From: Laurence Moore [REDACTED]
Sent: 01 August 2022 09:34
To: Anita Gardner <Anita.Gardner@arun.gov.uk>
Cc: Juan Baeza <Juan.Baeza@arun.gov.uk>
Subject: RE: A/43/22/PL.

Subject: A/43/22/PL.

I have now had an opportunity to discuss the application with my Team Leader, Juan Baeza and he agrees that the items detailed in my e-mails below namely bbq hut, summerhouse, hoop top fencing and removal of TPOd trees should be deleted from the application if it is to be recommended for approval by officers.

Drawing title
Landscape General Arrangement Plan

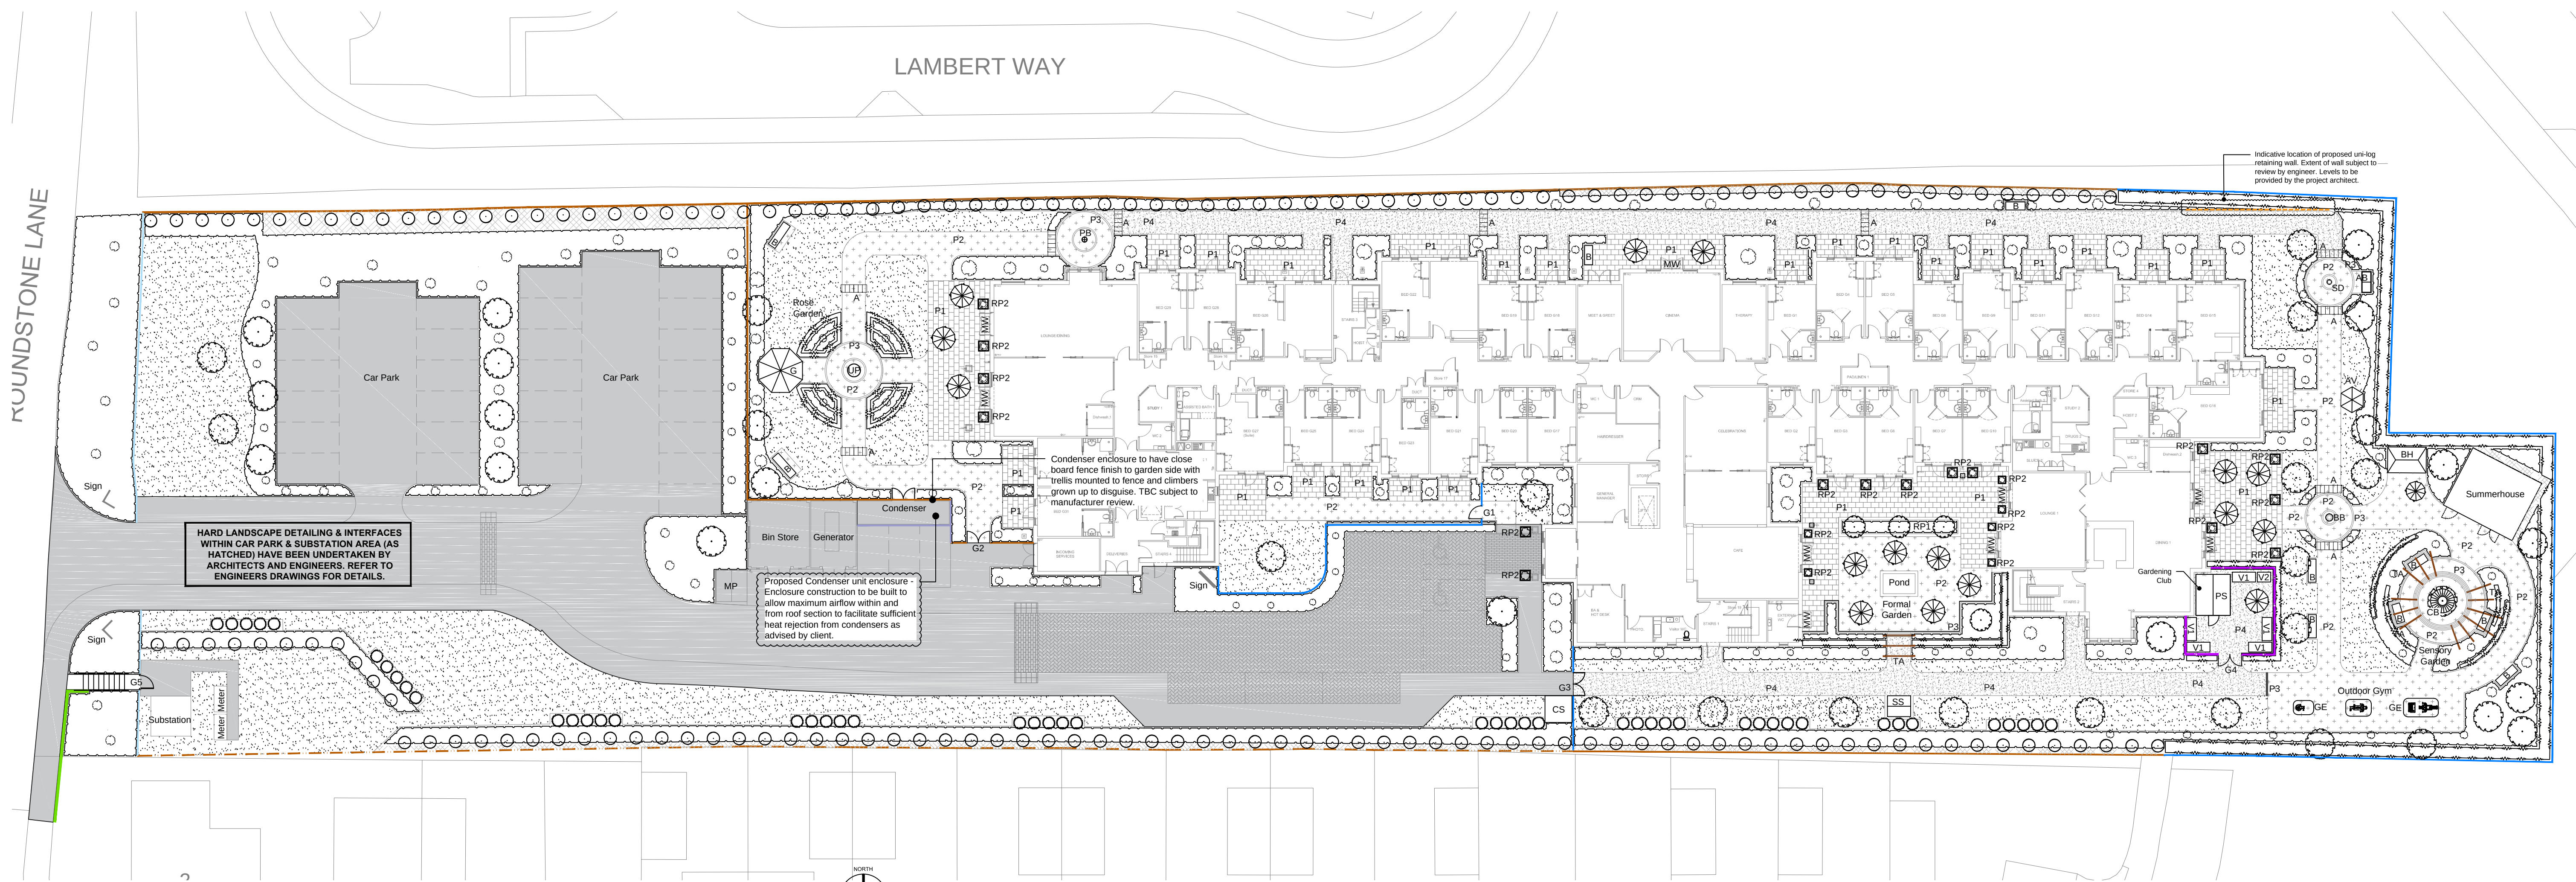
Further to our emails last week, I can advise the applicant is instructing architects and landscaping consultant to submit amended drawings to address your comments regarding summerhouse, bbq, and trees. I'll update you when the amended plans are likely to be submitted to you. We are hopeful they can be submitted soon.
